FW: M/98/25/HH 1 ELMER COURT

Please upload as sub plan for M/98/25/HH as: Proposed Plans and Elevations REV A

Good afternoon Rhiannon
Following up to your message to Jesse Chapman, please find attached a revised drawing that amends the side – east and west – elevations. The elevations now show the correct height to the side panelling.

06 SIDE (EAST) ELEVATION:

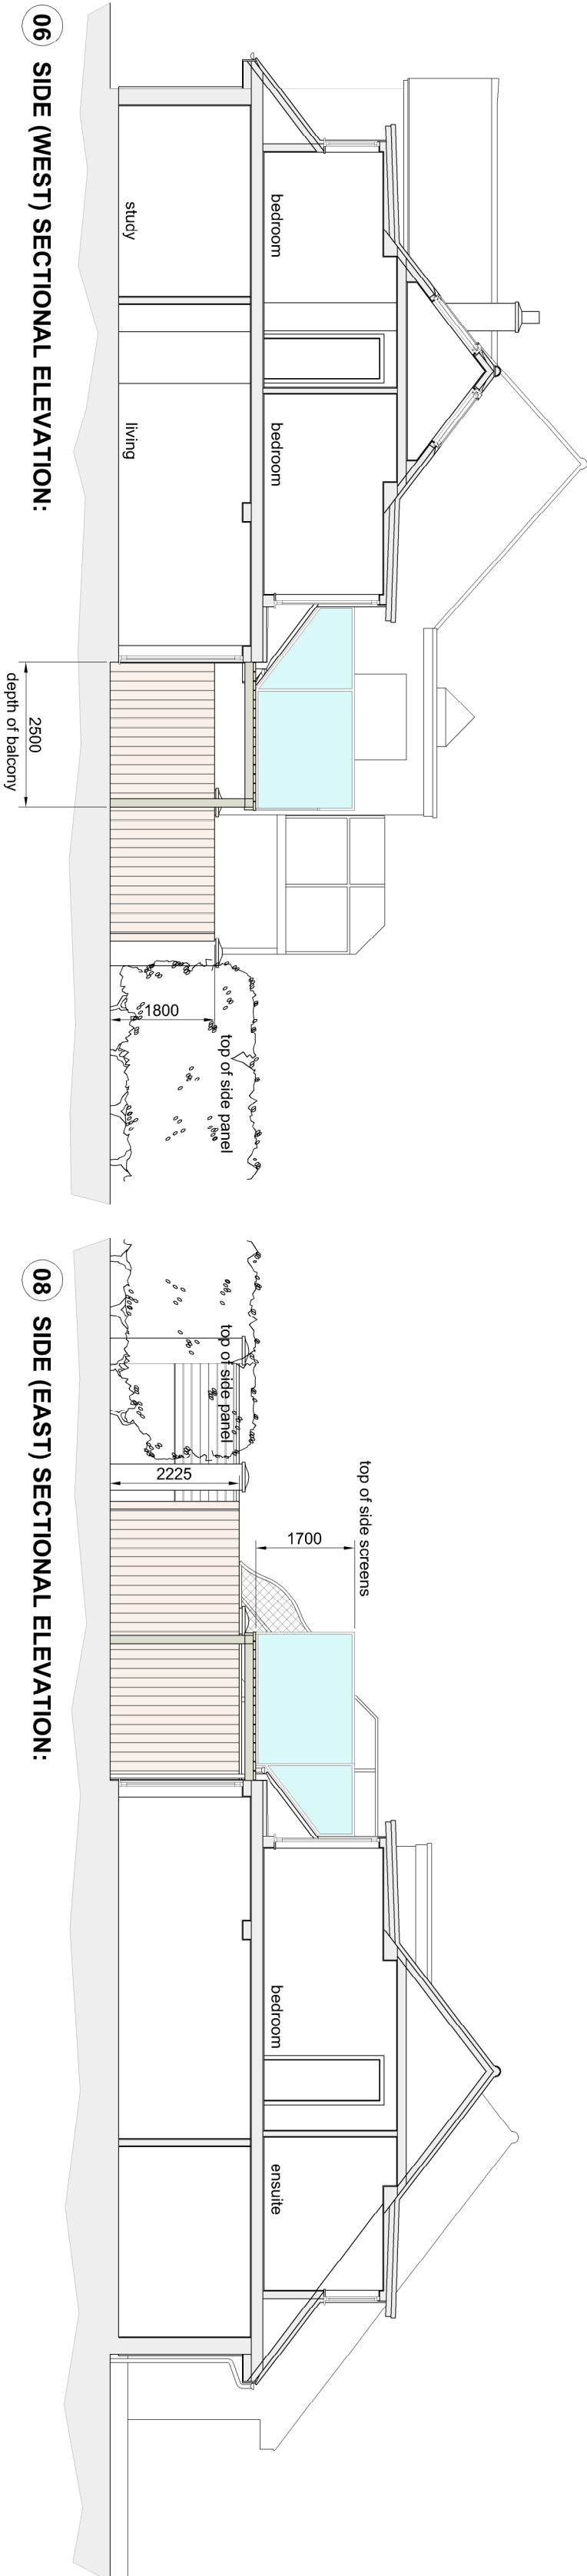
The annotations on the floor plans relating to the fixed side panels appear to be reversed. The east side is labelled as 1.8m, whereas this measurement appears to apply to the west side, and vice versa. As such they do not align with the proposed elevations.

Please could you provide amended plans with the annotations corrected.
